**Applicant:** Oxford University Development Ltd

**Proposal:** Discharge of Condition 15 (lighting strategy) of 18/00803/OUT

In accordance with Drawing number BBSP-HLEA-XX-XX-DR-E-708-001 Rev P03 (Electrical engineering systems external lighting layout) and document titled 'Stage 3 External Lighting Report' Rev P3 dated 04 April 2022.

DRAWING TITLE:
Electrical Engineering Systems
External Lighting Layout

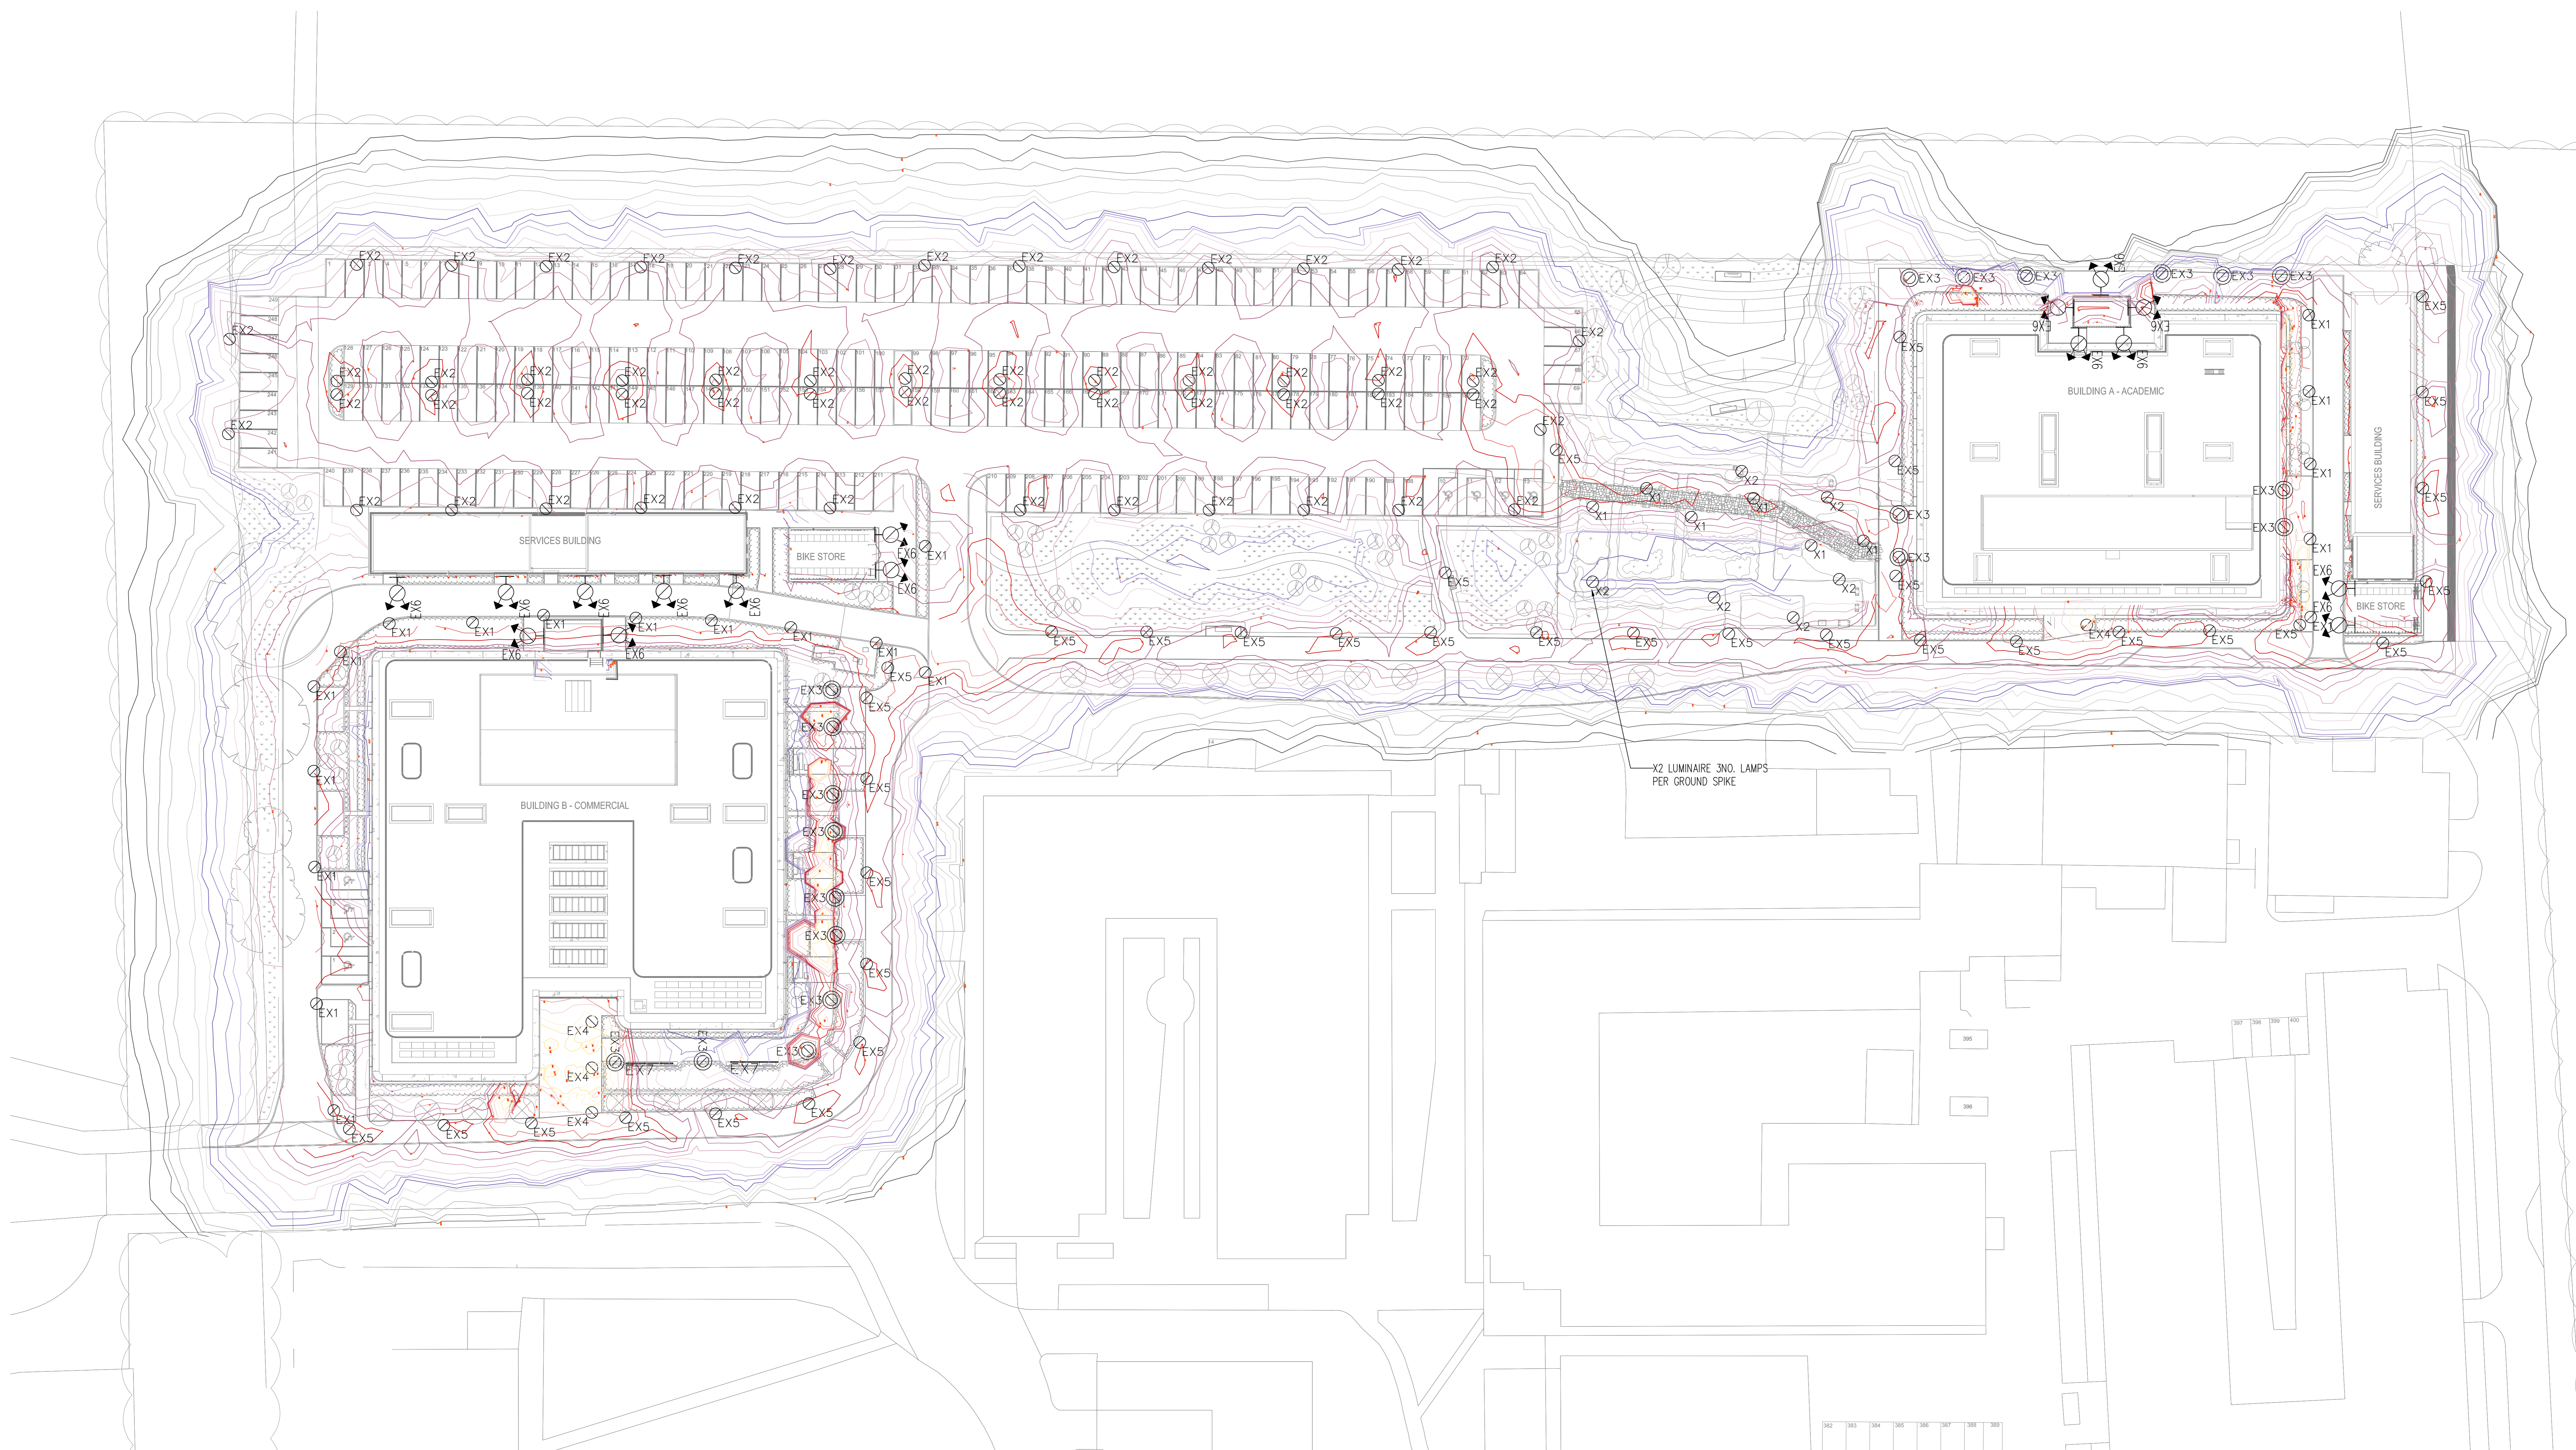
Ecology: *Lighting scheme is ok, what is a 'weed garden' and does it need to be lit in the evenings/mornings? Any lighting that can be avoided should be.*

The Council's Ecologist is satisfied with the discharge of condition 15 as long as *'the weed garden' is kept as dark as the luminance diagram suggests and must be kept unlit for most of the year as site further develops, to enhance the value to biodiversity'*.

Based on the above concerns the agent was contacted to provide further information, the ecology officer was then re-consulted who was satisfied with the information provided and has now removed the objection to the discharge of this condition.
